Re: Request for further information R/112/26/HH

Drawing No Revision
250078/ 04 A

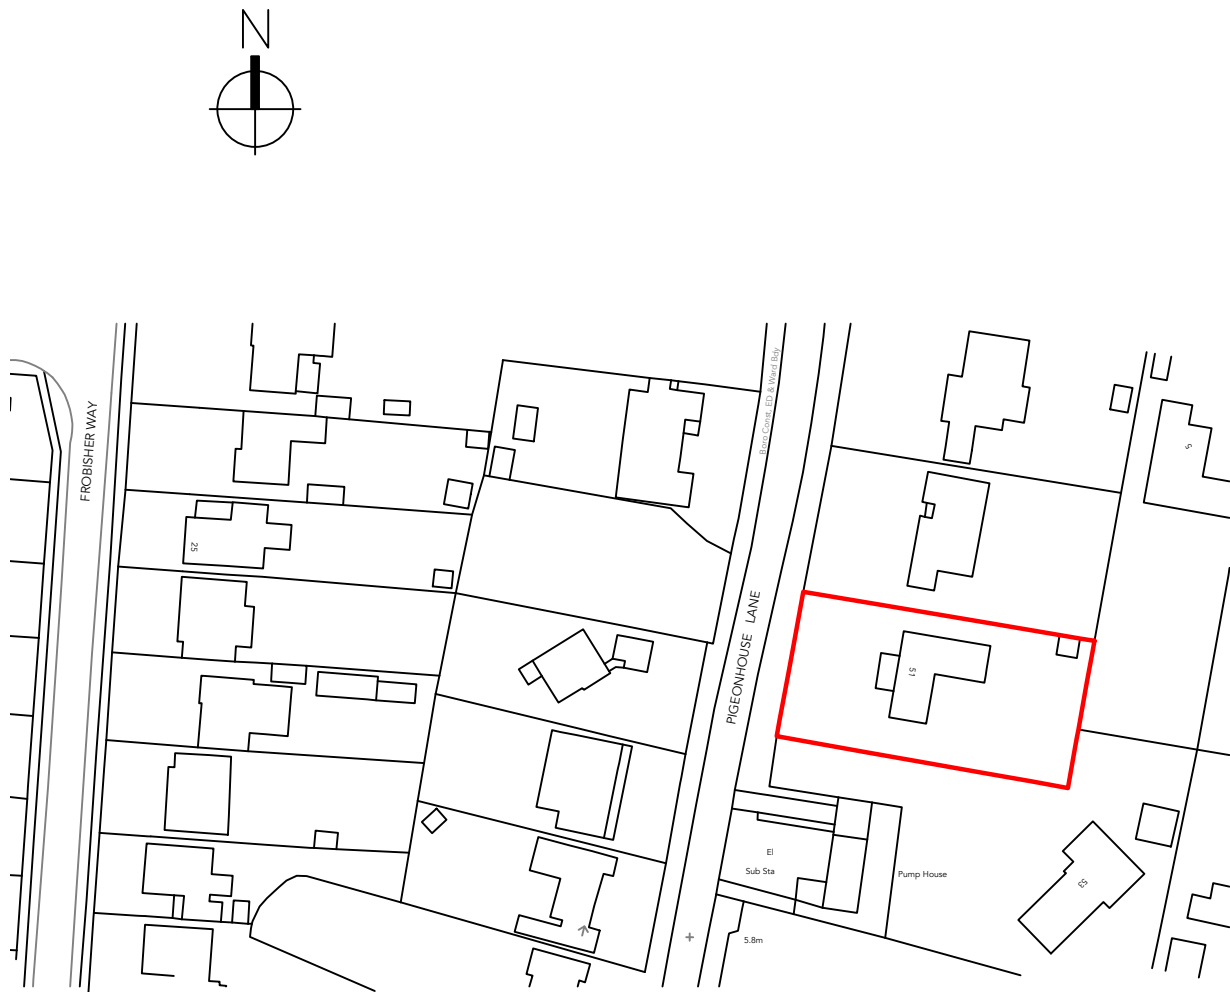
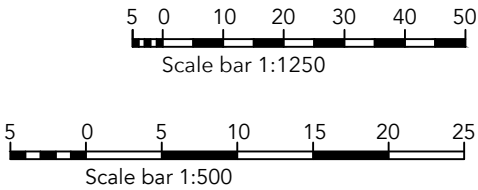
The existing ground floor plan you sent looks good now, however, the application is still invalid as the proposed patio and existing patio's need to be visible on the location and block plans. This allows the plans to stay consistent throughout.

I have never been asked to indicate existing patios on location plans - The scale of these is so small I think there is risk that the line indicating a patio could be misread as buildings. I am pretty certain indication of patios is not a requirement on a location plan however, if I am mistaken please can you direct me to where this requirement is stated in the validation requirements?

The patios are shown on the black plan drawing that I sent to you on the 10th August which I am re-attaching to this email.
